LANE COVE COUNCIL SUBMISSION

Ref: SSD - 13619238-Mod-2

Greenwich Hospital Redevelopment – 95-115 River Road Greenwich

Figure 2-3 Existing Stormwater Network

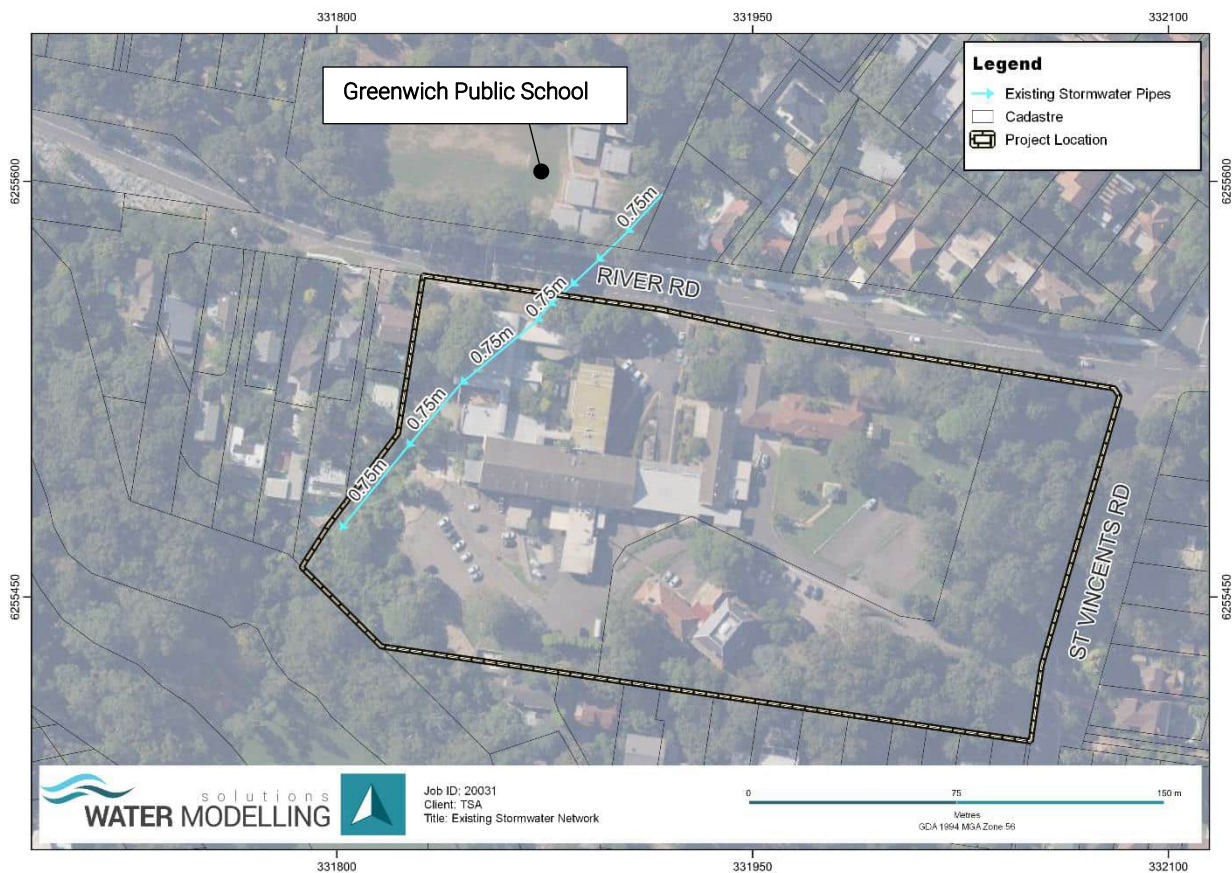
Council's stormwater network includes a major drainage line that currently runs directly beneath the approved significant development footprint. Council raised this matter during the assessment phase and expressed concern regarding the risks associated with retaining the existing stormwater infrastructure beneath the proposed building envelope.

The SSDA conditions do not clearly mandate relocation measures consistent with Council's standard engineering practice. As a result, the developer has proposed to undertake construction works on top of the existing stormwater system. Throughout the history of the development Council has twice requested the Department to include standard conditions to protect our stormwater assets.

- Major structure may compromise the structural integrity of the stormwater asset.
- Long-term access for maintenance, inspection, and future renewal would be severely constrained if the asset remains beneath the building footprint.
- Any failure of the drainage system in the future could have substantial operational, safety, and financial implications.

Council formally objected to the proposal to retain and work around the existing stormwater

infrastructure. Consistent with Council's standard approach applied to other developments within the LGA, Council recommended the relocation or redirection of the drainage line outside the building footprint. This would ensure:

Figure 6 Hospital level 1 basement parking layout, as approved (top, over page) and as proposed to be amended (bottom)

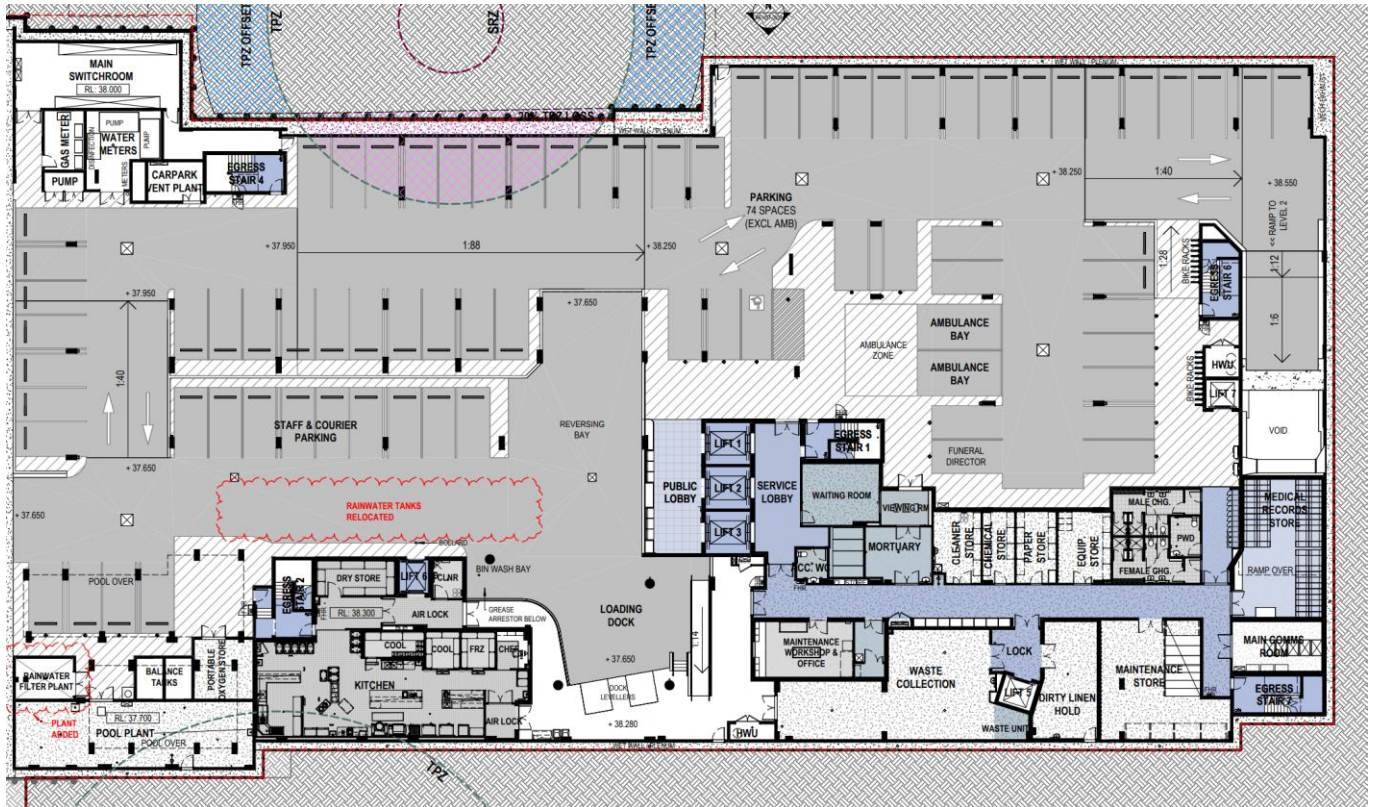
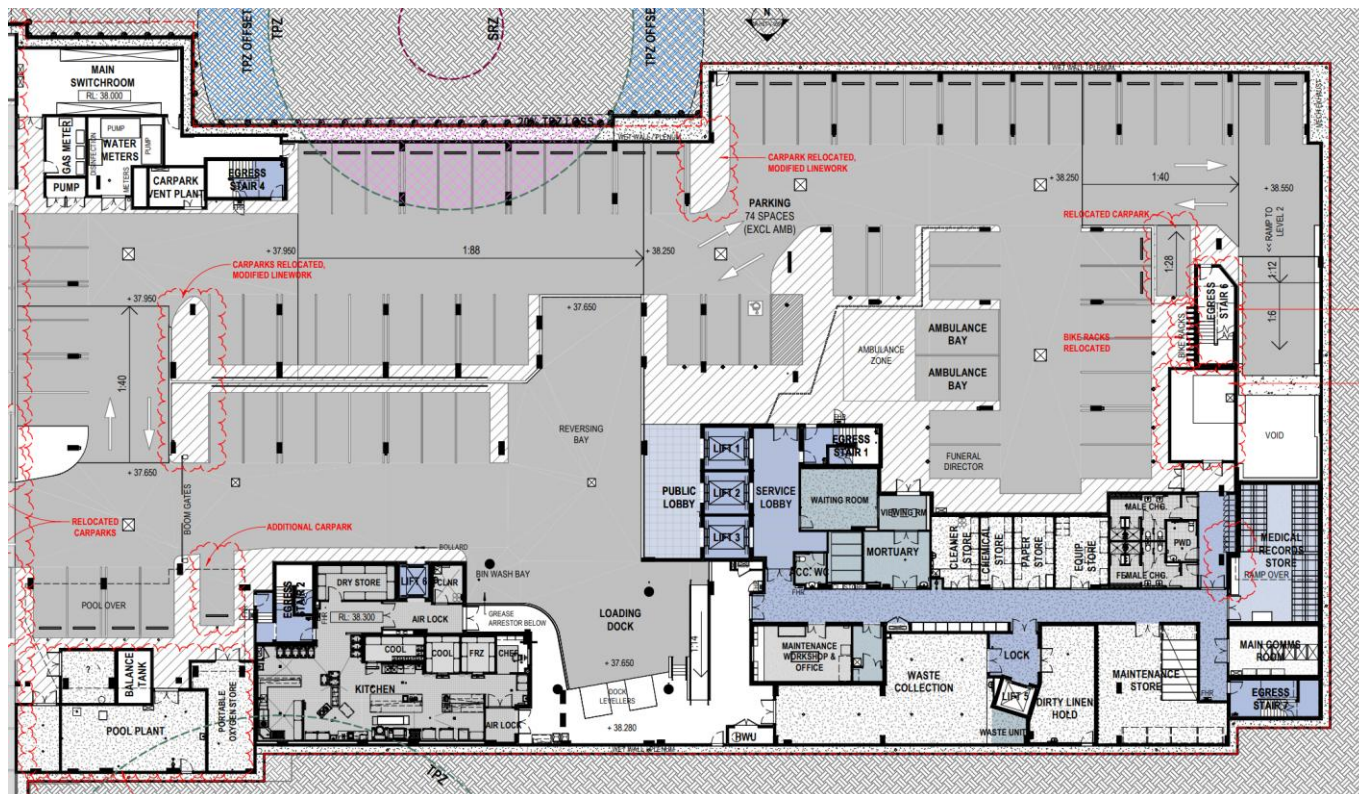
The proposed changes to the carpark and driveway including are considered acceptable by Council and no objections are raised.
